Saffron Lodge, 46 Kingsway
Craigweil, Bognor Regis
West Sussex, PO21 4DN

My Ref: AW/344/14/HH-1

11th February 2015

Ref: **OBJECTION : AW/344/14/HH (68 The Drive, Craigweil)**

ROOF PLAN

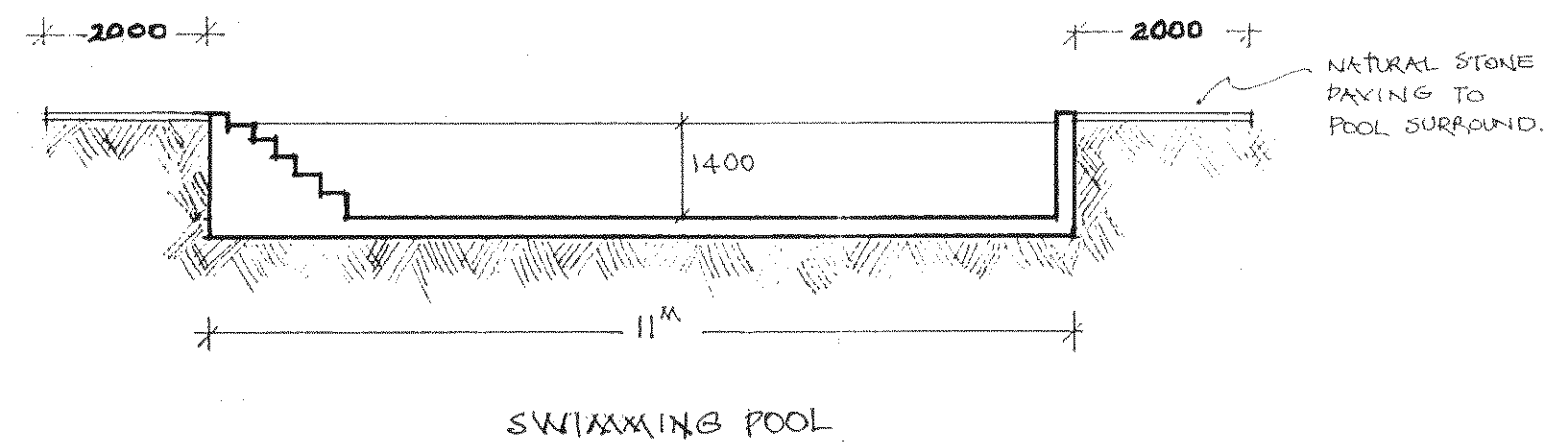
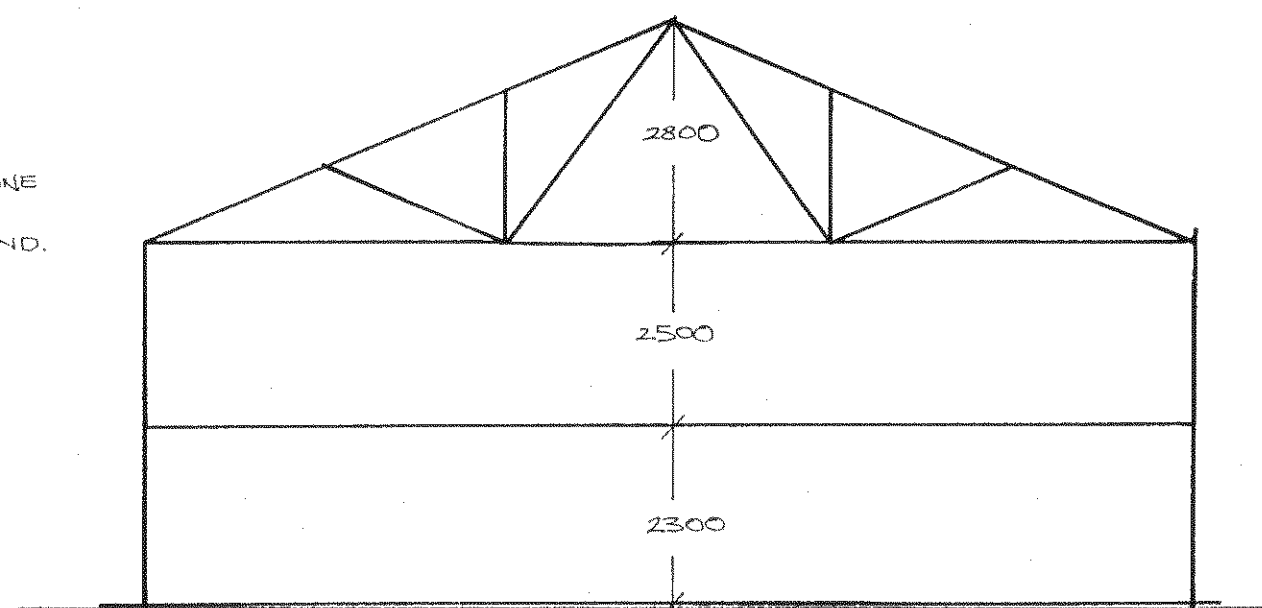
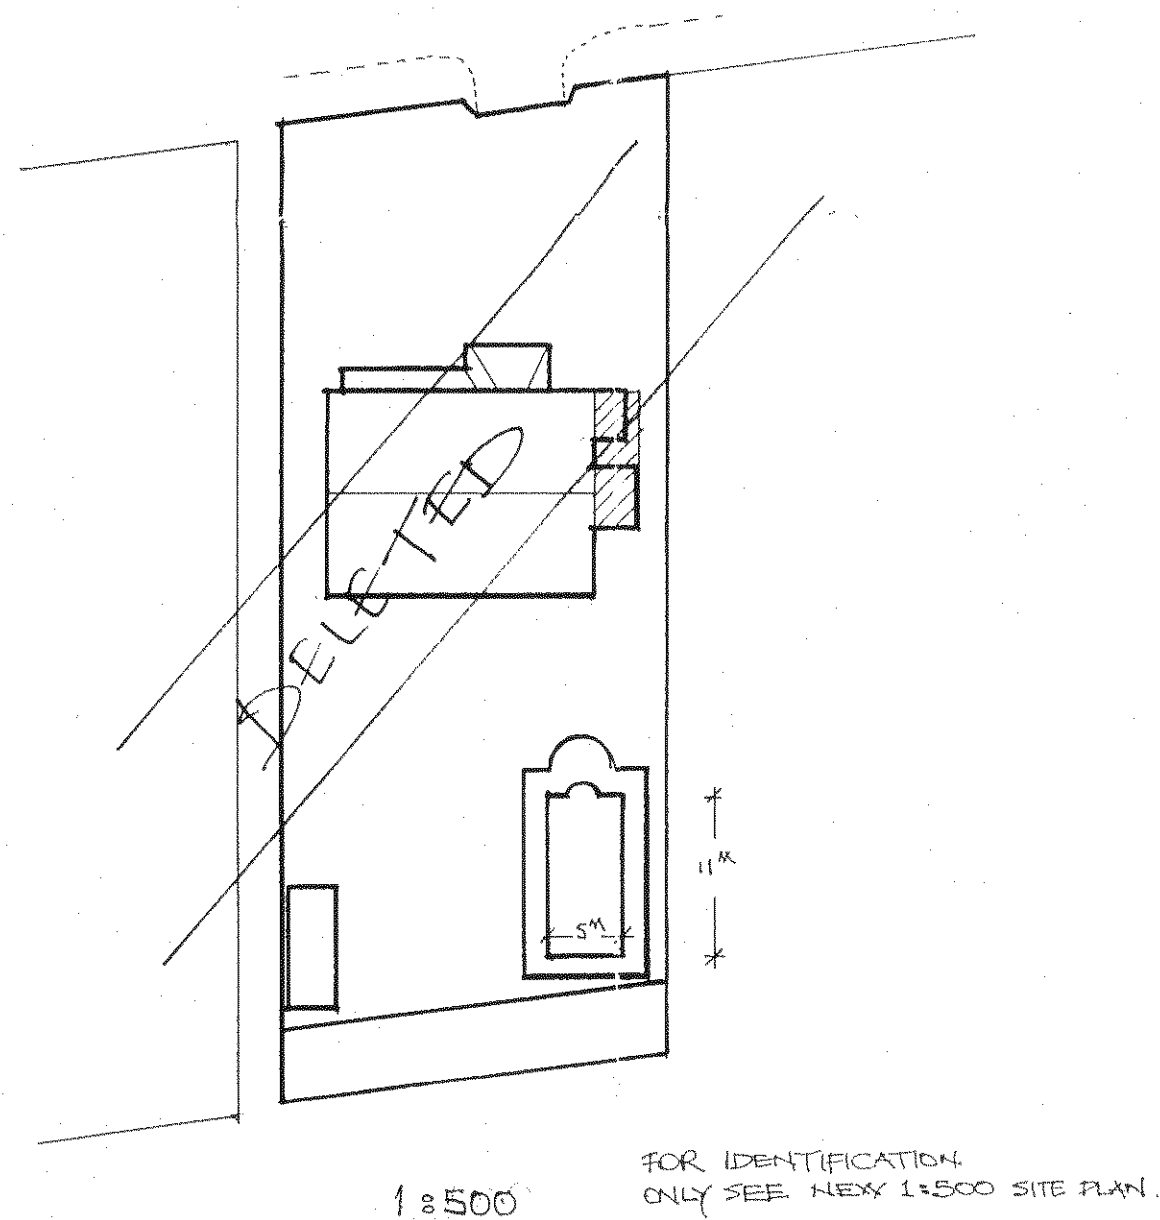
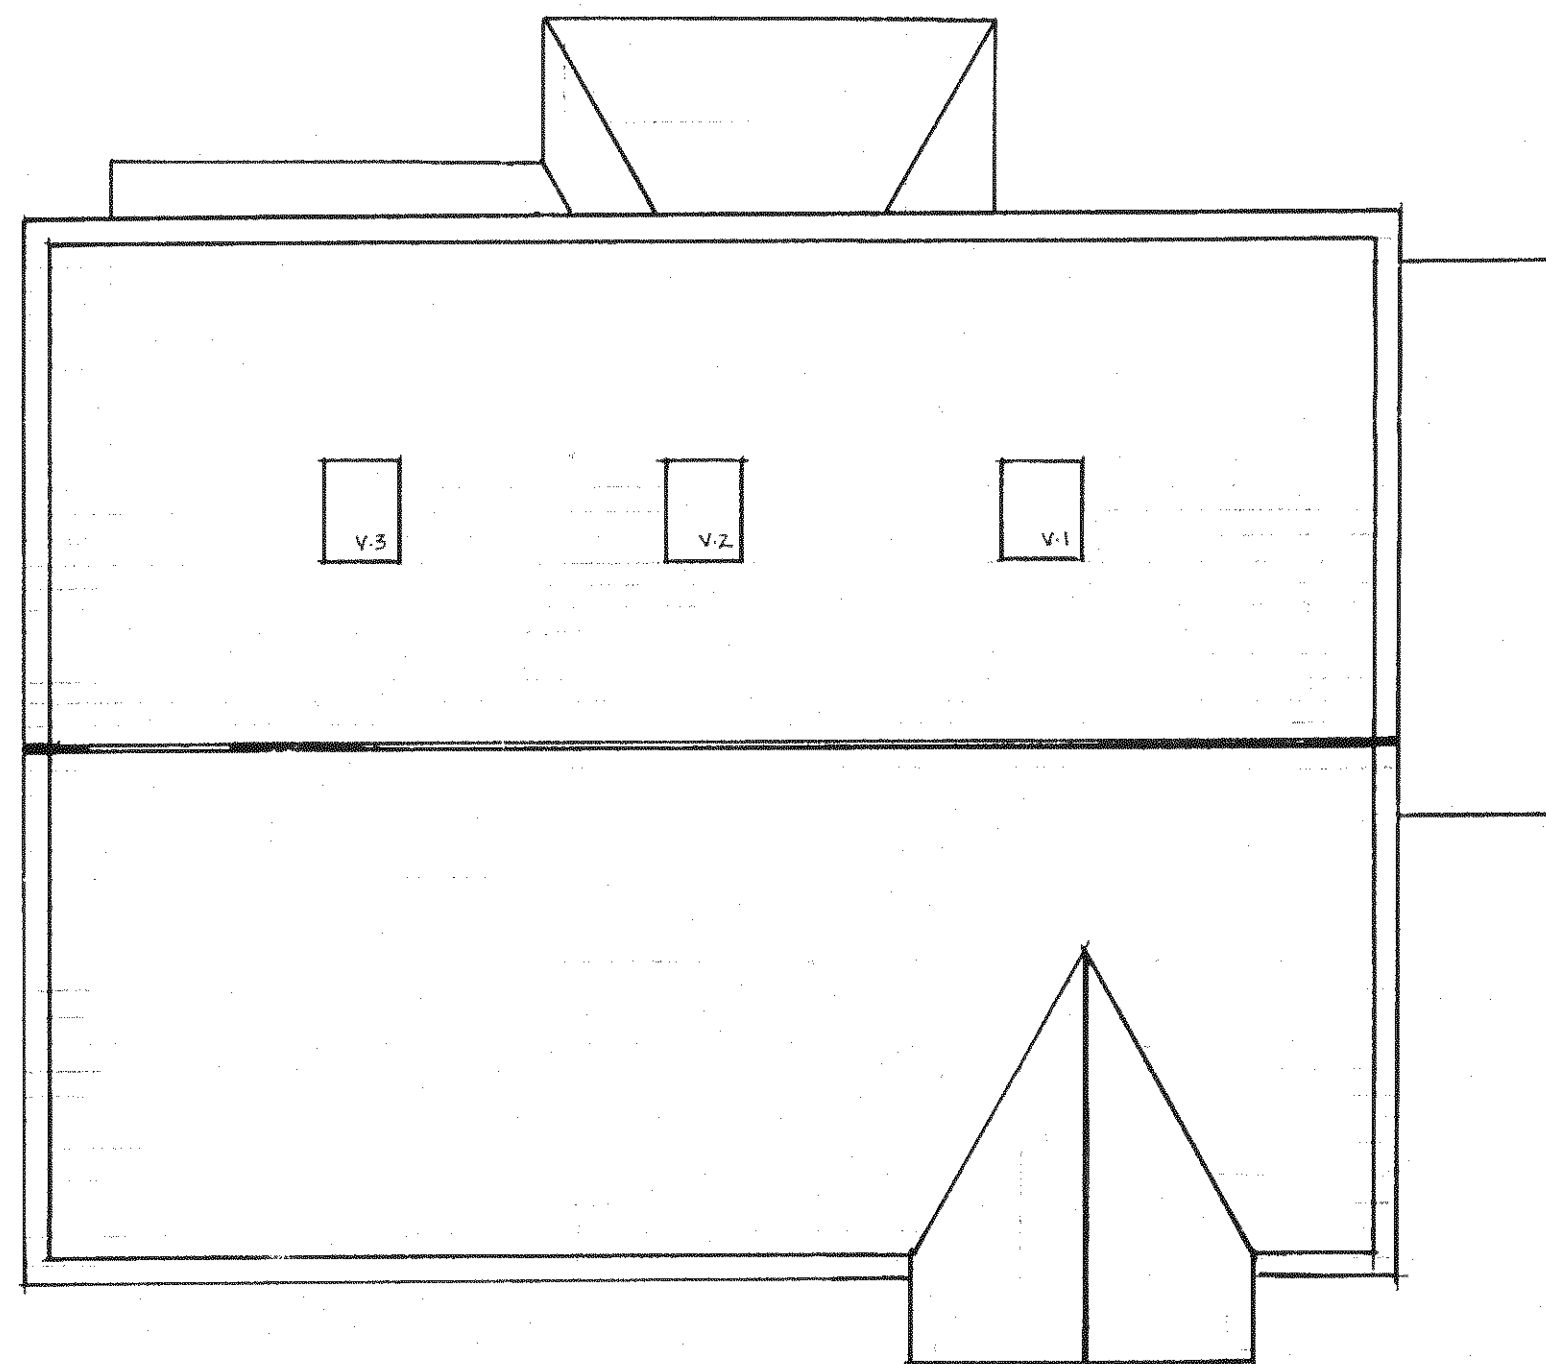
15. It is a pity that within these plans there is the removal of the roof of the building. I do not believe that the structure is in such poor condition to warrant that. The suggested replacement however, includes not only a new tile format but also the provision of 'lights' in the roof slope directly facing the Conservation Area on The Drive. It is presumed that the north face is selected because there are also plans to install solar panels on the southern slope of the building. I ask that the Officer judging this application insists that the roof lights on the northern slope are of 'Conservation Standard' non-opening windows. I am aware that planning permission is not required but hope the Officer can influence this matter.

EAST ELEVATION - PROPOSED.

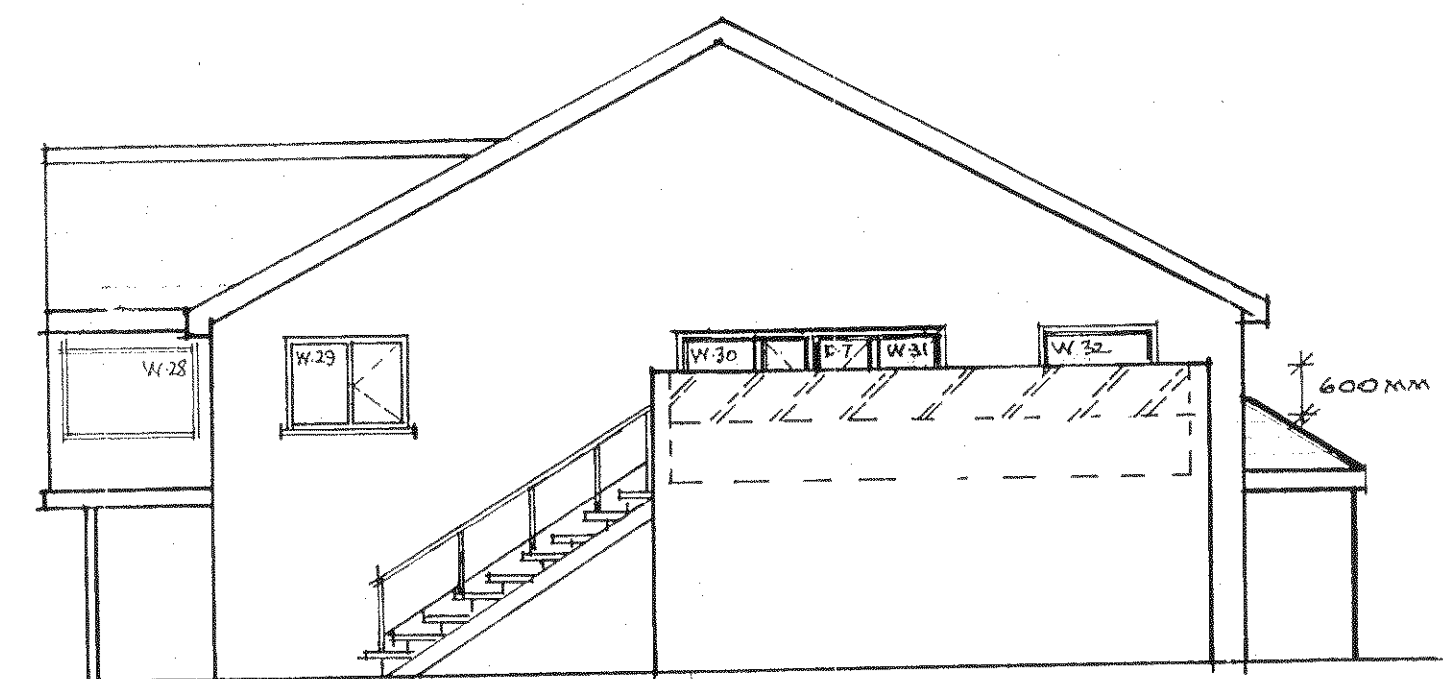
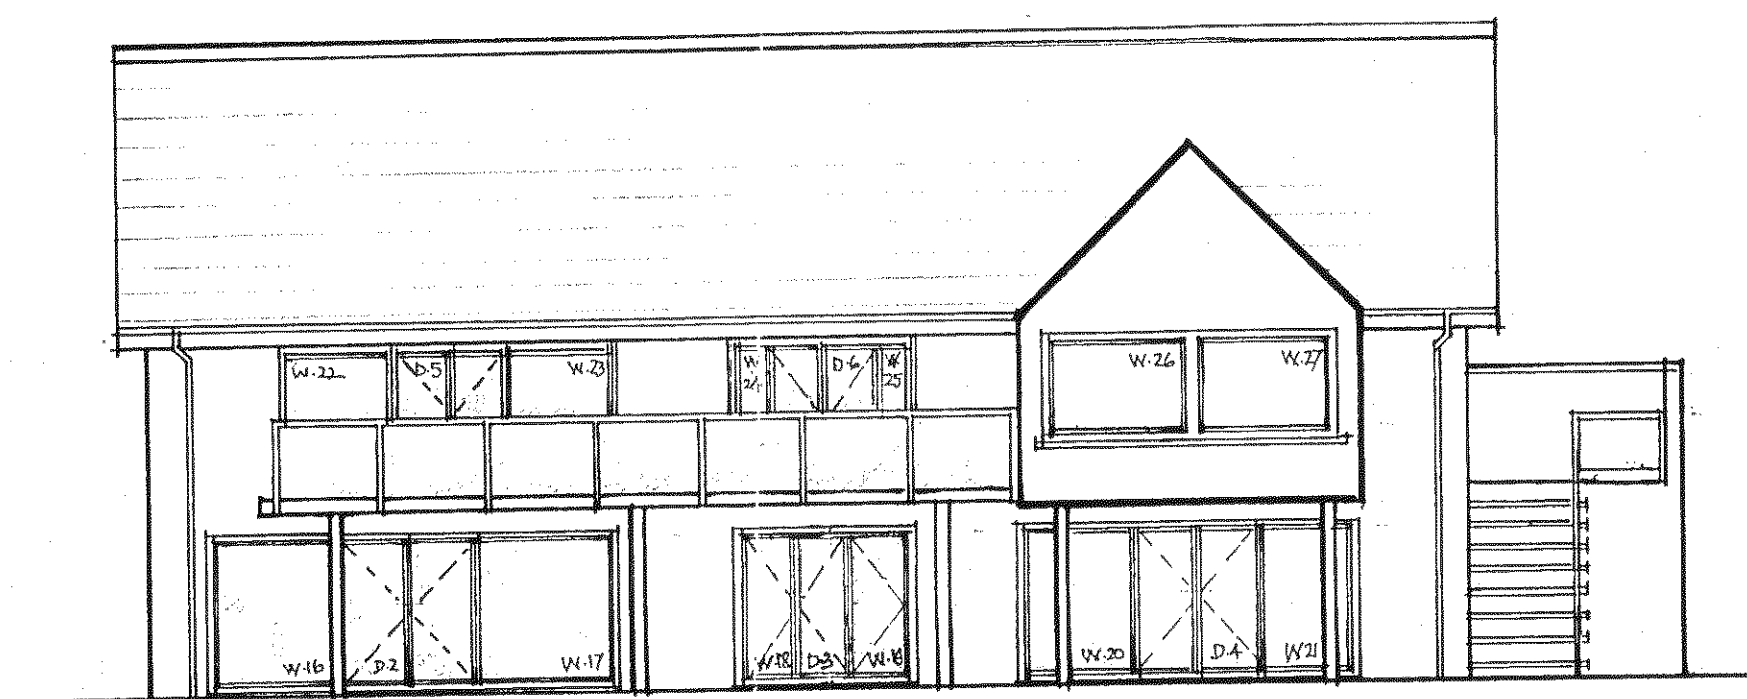
4. In addition, by removing the broad central stairway to the south of the building, access between garden area and the kitchen/dining/communal areas on the 1st floor **will all be by the replacement stairs/terrace** to the east of the building.

5. The attached photographs illustrate the close proximity to the neighbour **at both ground floor and first floor levels**, the "terrace" being extended toward and further along the neighbours viewpoints only a short distance away.

6. Not only is the increased footprint of that "terrace" an intrusion upon the neighbour, but the plans indicate (and Mrs Gardner seems not to worry about it) the newly constructed panels to the replacement timber and steel structure are to **CLEAR GLAZING**, which means not only will the neighbour hear intrusive noise, but the adjacent neighbours and their visitors will also be clearly visible at close quarters. The height of the eastern 'terrace' balustrading surely must also **be raised to 2M/6 feet**.
